**NORTH FALLS**

*Offshore Wind Farm*

# **Applicant's Response to Natural England's Deadline 5 submissions**

Document Reference: 9.86  
Volume: 9  
Date: June 2025  
Revision: 0

Figure 3.28 Predicted seabed level change during disposal at slack water near high water during neap tide. Horizontal hash = Kentish Knock East Marine MCZ

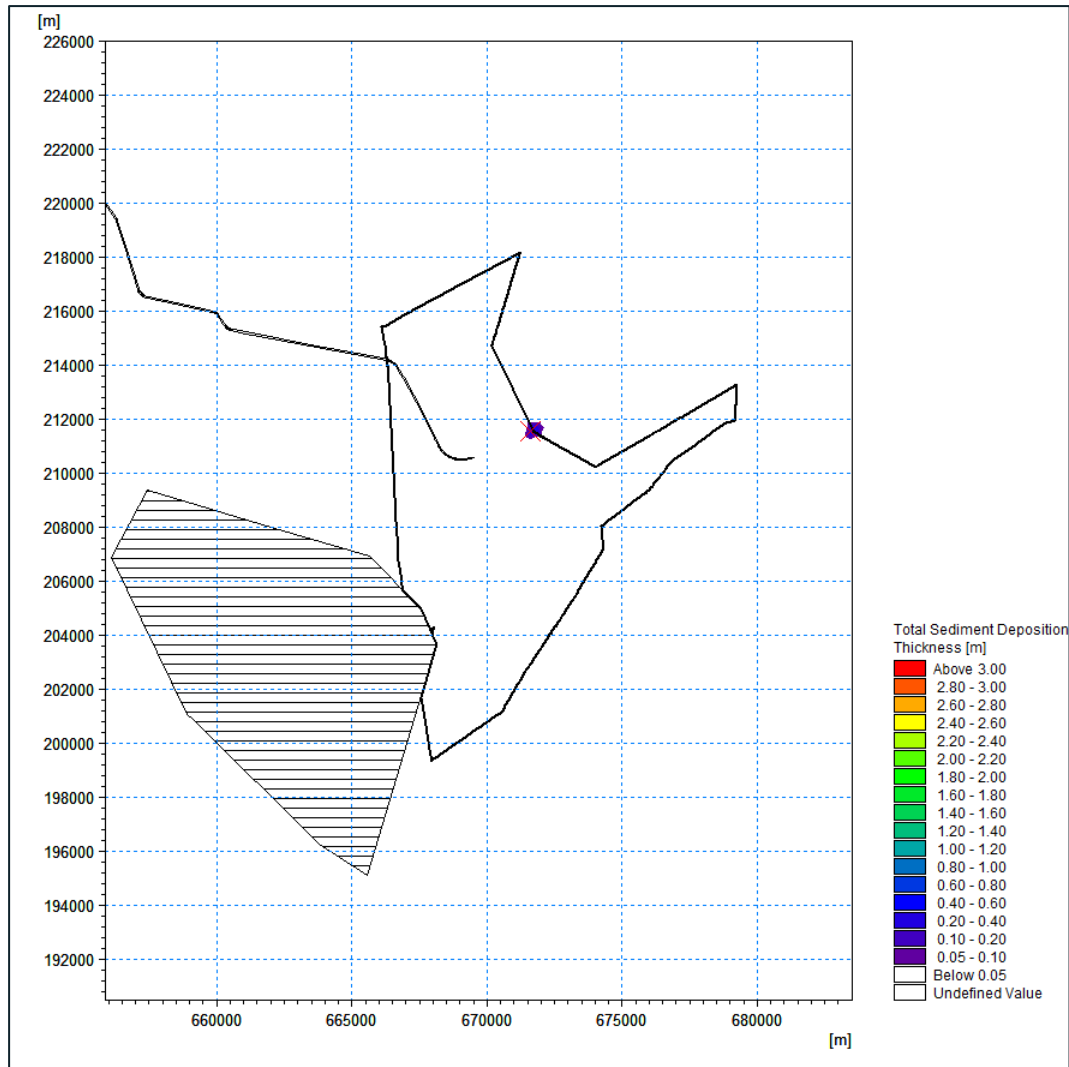
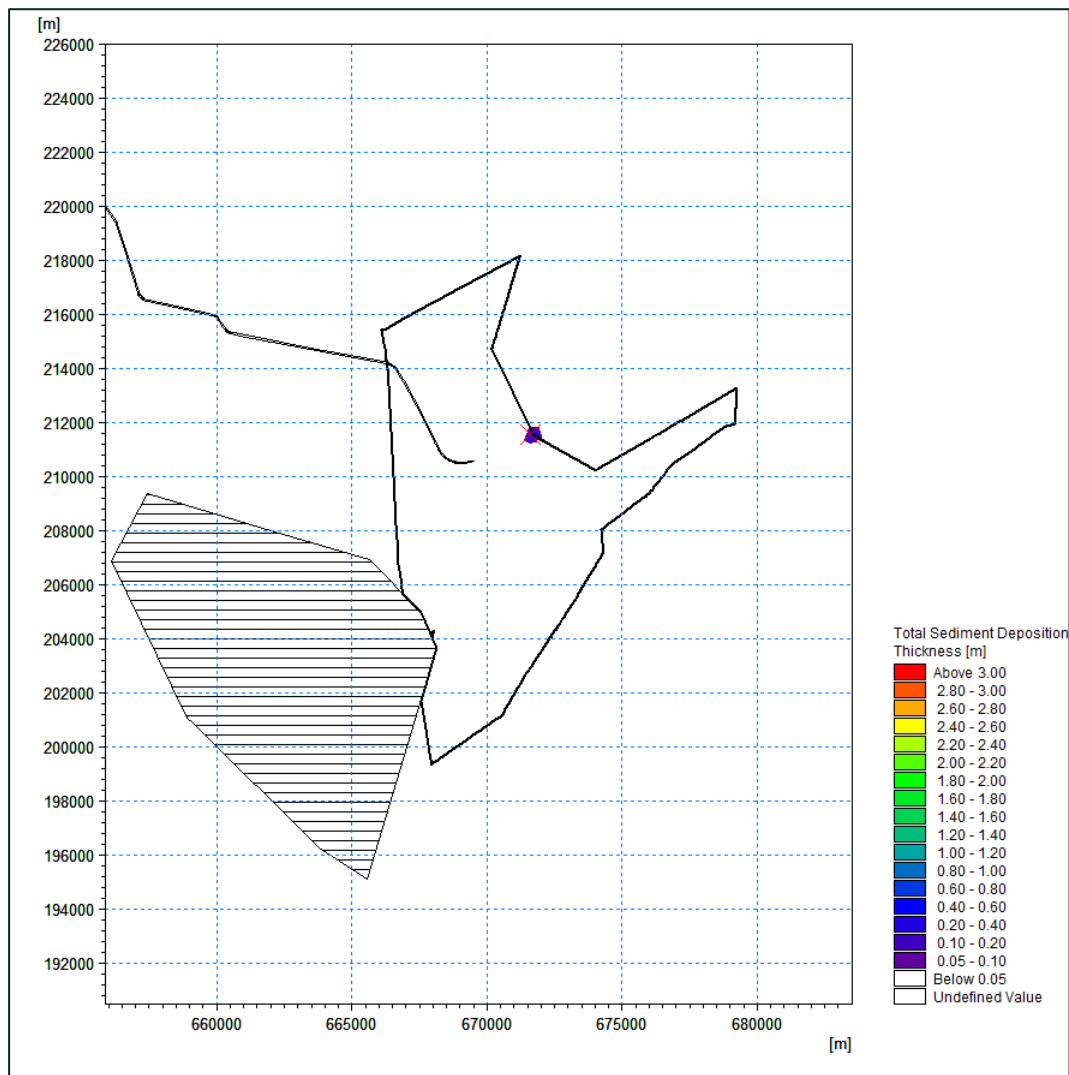
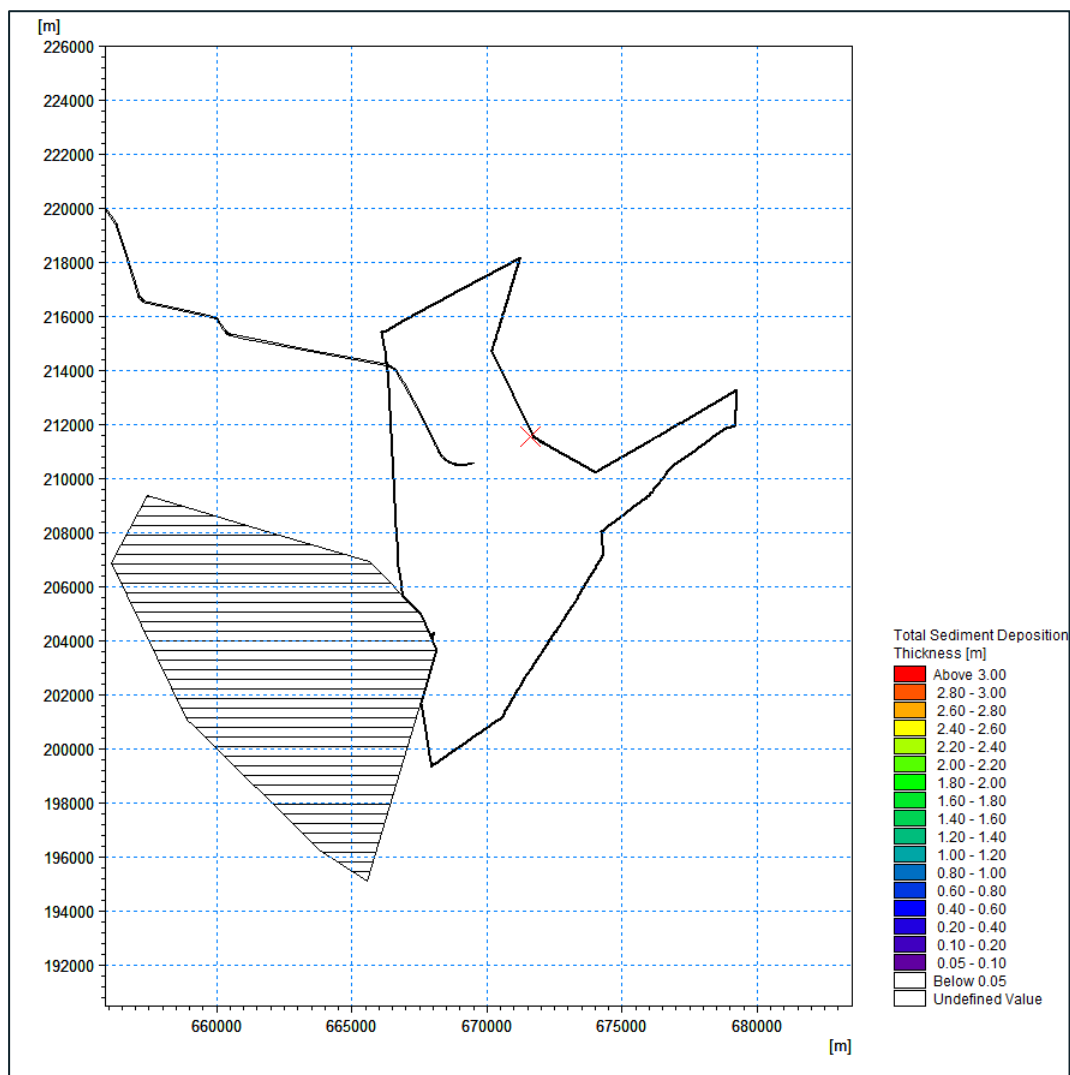
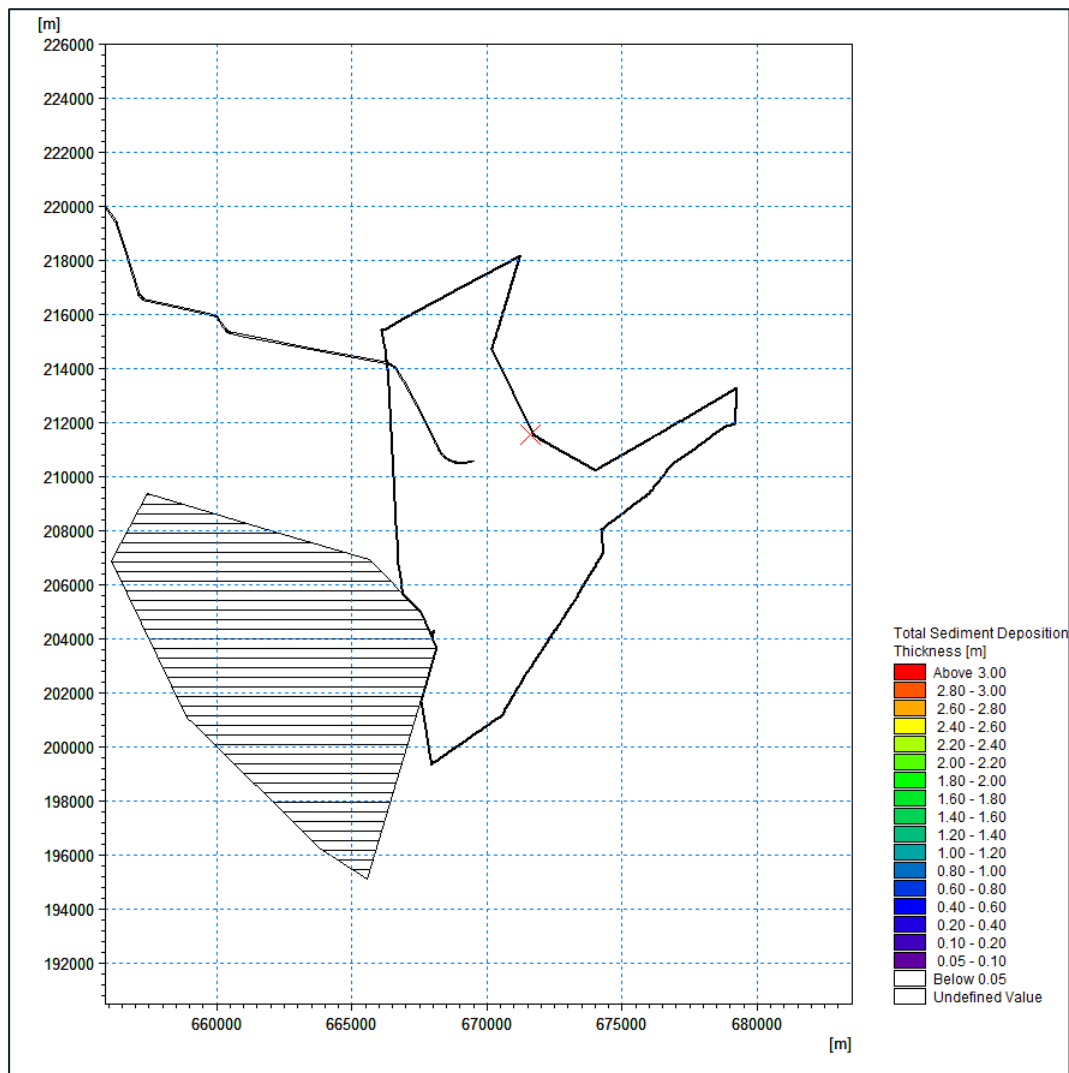
REP5-104_e5	5	6.15	<p>Natural England notes that the model setup for sediment disposal within the array has used a worst-case location for sediment dispersal at the northern end of the array. This shows that sediment deposition following sediment disposal within the array may extend up to 750m with a thickness of up to 0.5m. Given that there is the potential for sediment disposal to take place anywhere within the array, we advise that model output should be provided for sediment disposal adjacent to the MCZ.</p> <p>We also note that the modelling has not considered sediment dispersion near MLS SAC due to sediment disposal within the ECC disposal site. Therefore, the WCS for plume dispersion and associated sediment deposition due to disposal in the ECC needs to be clarified with respect to impacts on MLS SAC.</p>	<p>We advise that model output should be provided for a sediment disposal location adjacent to KKE MCZ, to inform understanding of the potential impacts to seabed level change at the MCZ due to sediment disposal.</p> <p>We also advise that the WCS for sediment disposal in the ECC with respect to MLS SAC, should be considered in the assessment.</p>	The modelled disposal location is the worst case scenario for sediment dispersion due to the shallower depth at the selected location. As discussed in Section 3.8 of the Sediment Dispersion Modelling – Results Interpretation <b>[REP4-040]</b> , the modelling of this worst case disposal location validates that the Mass Flow Excavation (MFE) method for seabed levelling represents the worst case scenario, over dredging and disposal. MFE would not require sediment disposal as sediment is levelled by blasting the seabed with seawater and therefore modelling of MFE across the array area, including up to the 50m buffer from the KKE MCZ fully represents the worst case scenario.

**Figure 4.1 Predicted percentage change in current speeds due to the Project during peak flood of spring tide (positive indicates an increase in current speed and negative indicates a decrease in current speed)**

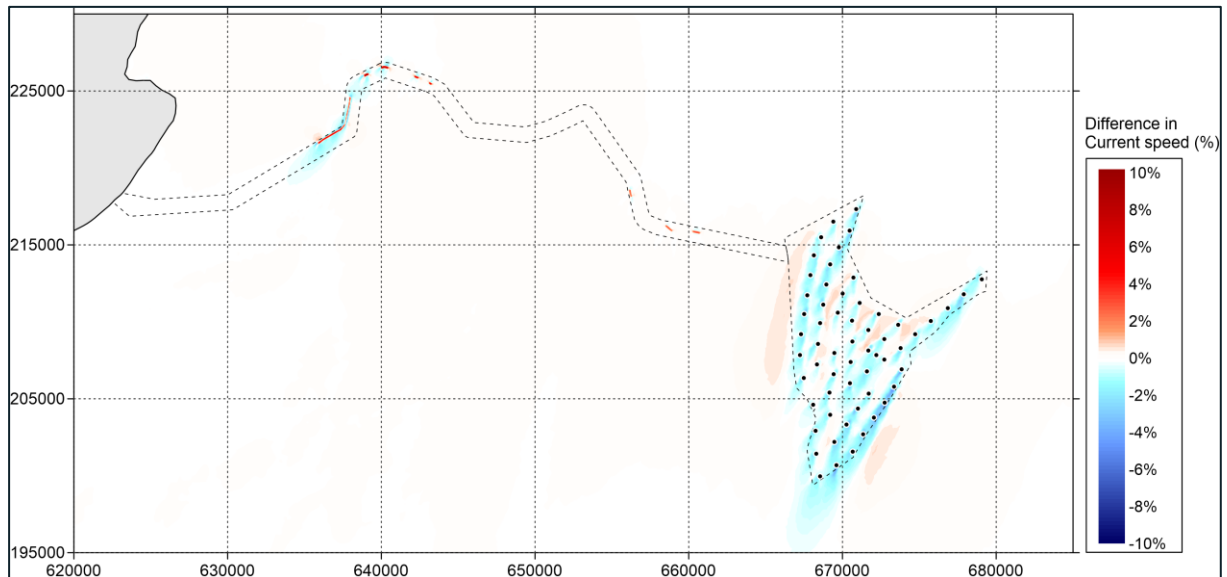
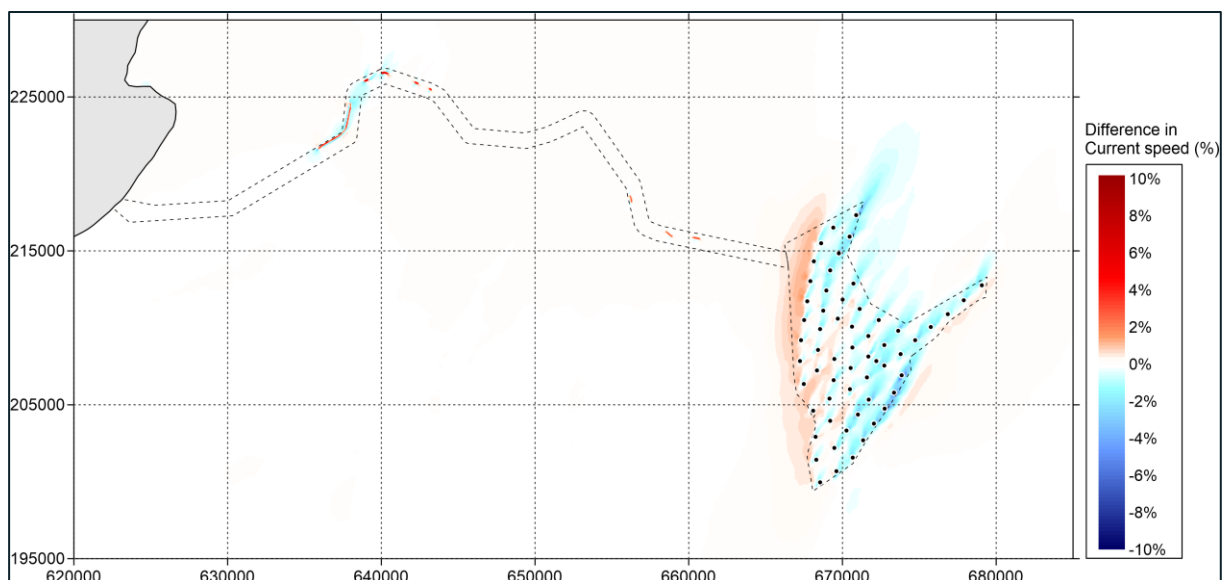
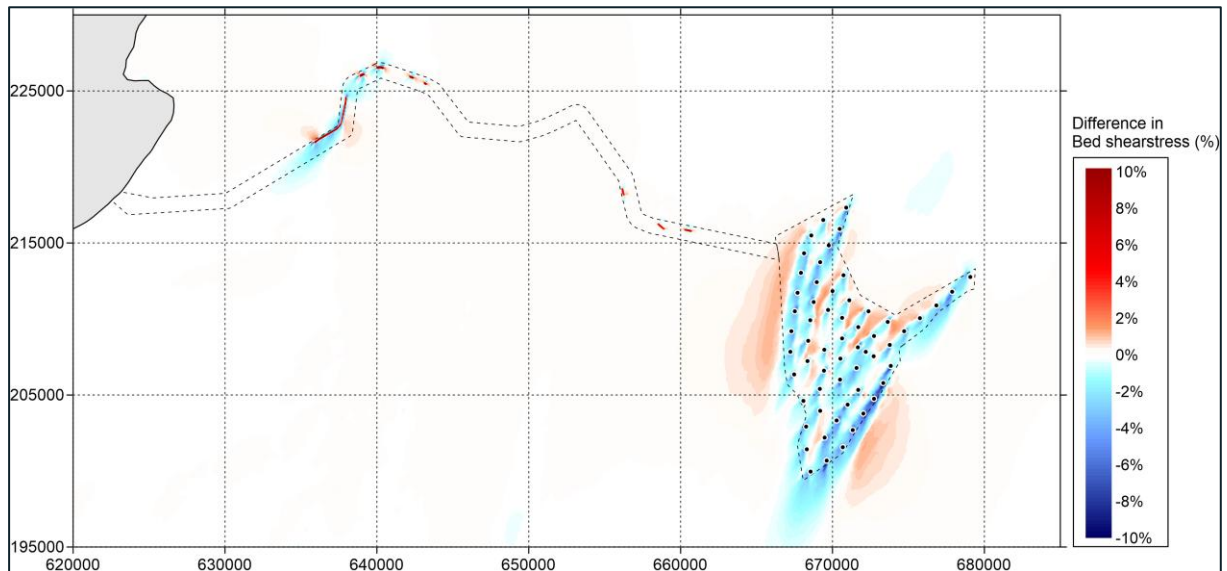
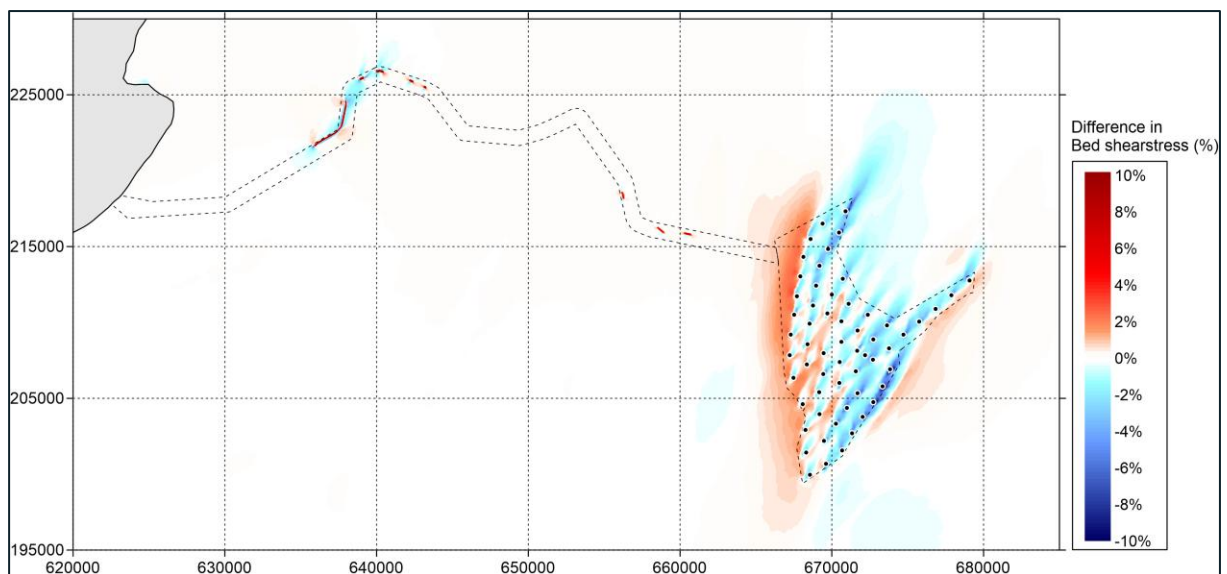
REP5-104_e3	3	6.3.2 & Table 6.2	Whilst changes in bed shear stress have been presented, Natural England notes that the baseline absolute bed shear stresses have not been presented. Moreover, the predicted bed shear stress changes have not been assessed against the threshold for sediment movement for the different sediment fractions at the key areas of interest (e.g. SAC, MCZ, offshore sandbanks). Natural England advises this information is needed to inform understanding of potential changes to deposition and erosion rates, seabed morphology, and seabed sediment composition due to the proposed development.	We advise that the modelled changes in bed shear stress need to be presented/considered relative to baseline absolute bed shear stresses and the threshold for sediment movement for different sediment fractions. Furthermore, the predicted changes in bed shear stress need to be evaluated in terms of impacts on erosional and depositional processes near and on the seabed, seabed morphology, and seabed sediment composition at the key areas of interest (e.g. KKE MCZ, MLS SAC, offshore sandbanks etc.).	The predicted absolute changes in bed shear stresses were provided in the Hydrodynamic and Dispersion Modelling Report [see Figures 5.60 to 5.67, <b>9.54, Rev 1</b> ]. They show that the predicted absolute change in bed shear stresses in the KKE MCZ and MLS SAC are less than 0.05N/m <sup>2</sup> . The revised report now presents the baseline absolute bed shear stresses as Figure 5.36 to Figure 5.43 <b>[9.54, Rev 2]</b> . Baseline magnitudes of greater than 2N/m <sup>2</sup> were predicted across both the MCZ and the SAC. A change of less than 0.05N/m <sup>2</sup> on top of these baseline values would have no discernible effect on the sediment sizes that can be transported before and after the changes.
